REF No. DOC16/406804
Your REF No: SSD 7073

Mixed Use Redevelopment of 85 Harrington Street and 68-72 Gloucester Street, The Rocks and Variation to the Sydney Cove Redevelopment Authority Scheme – State Significant Development no. 7037

SCALE	1:200 @ A2	PROJECT CODE
DATE	11/09/2015	GA85H
SHEET NO.	DA-2011	REVISION
		I

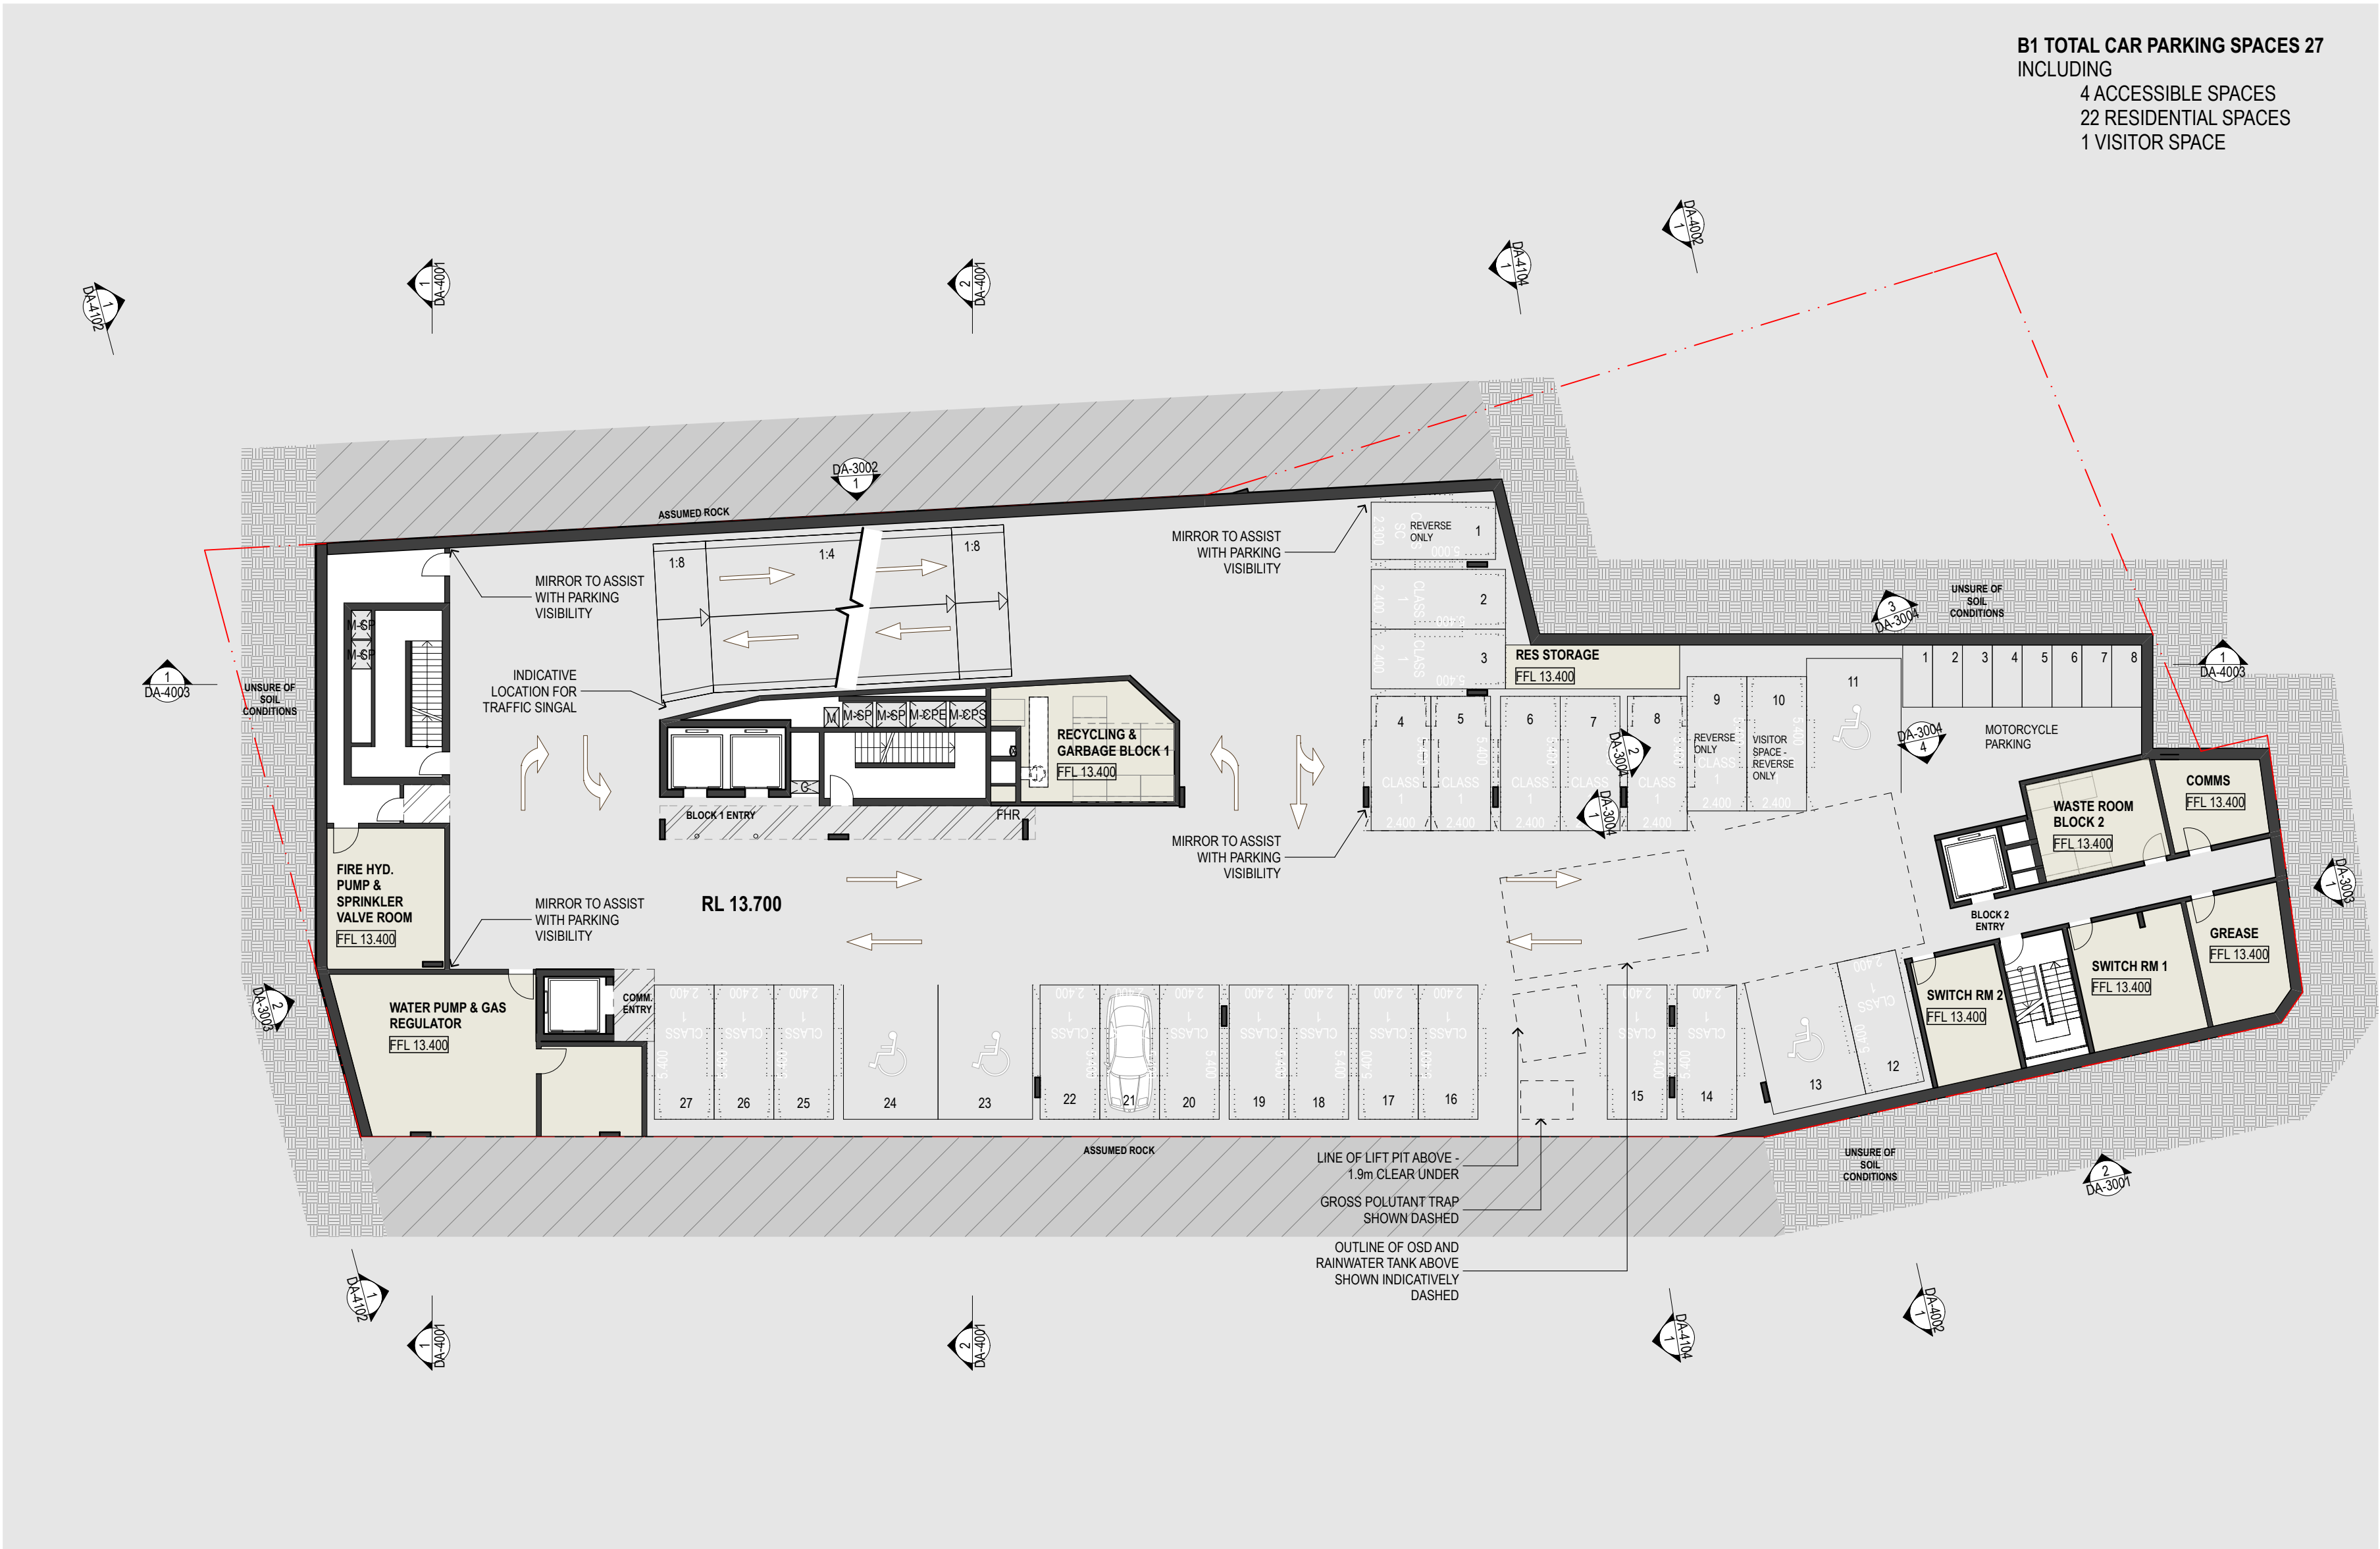
- 3. Submit to the Department of Planning and Environment for assessment and approval a revised architectural drawing of no. DA-2002 with title 'Plans Level 2 Floor Plan' revision I, prepared by Francis-Jones Morehen Thorp Pty Ltd dated 1/02/2016. The revision shall include retention of all other fabric (basement walls) that has been assigned a significance grading of *High* and *Exceptional* in the basement of the Bakers Terraces; as indicated in supporting document entitled *Conservation Management Plan, Bakers Terrace, 66-68 & 70-72 Gloucester Street, The Rocks*, prepared by Urbis Pty Ltd dated January 2016 (reference p100).**

5 PLAN Level 5
1:500

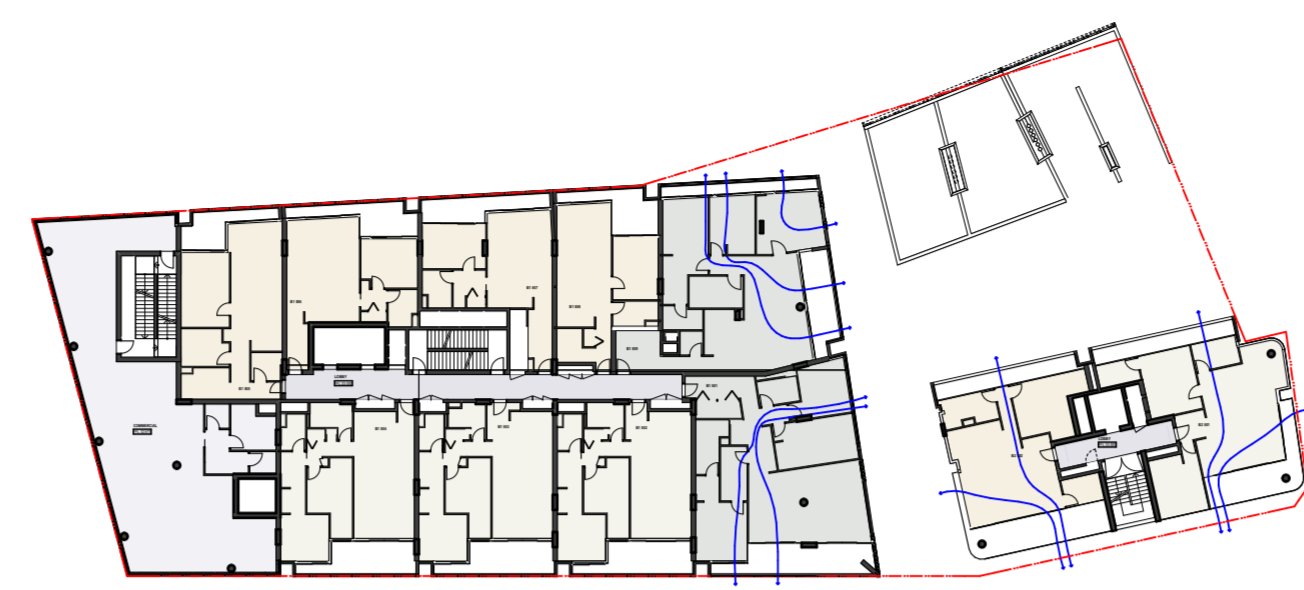
4. **Submit to the Department of Planning and Environment for assessment and approval revised architectural drawings to remove the concrete awning and side panels to the balconies of building Block 2 unit numbers B2 501 and B2 502 (Level 5 Floor Plan).**

Reason: to reduce the height and scale of the concrete awning and side panels to balconies facing the Bakers Terraces.
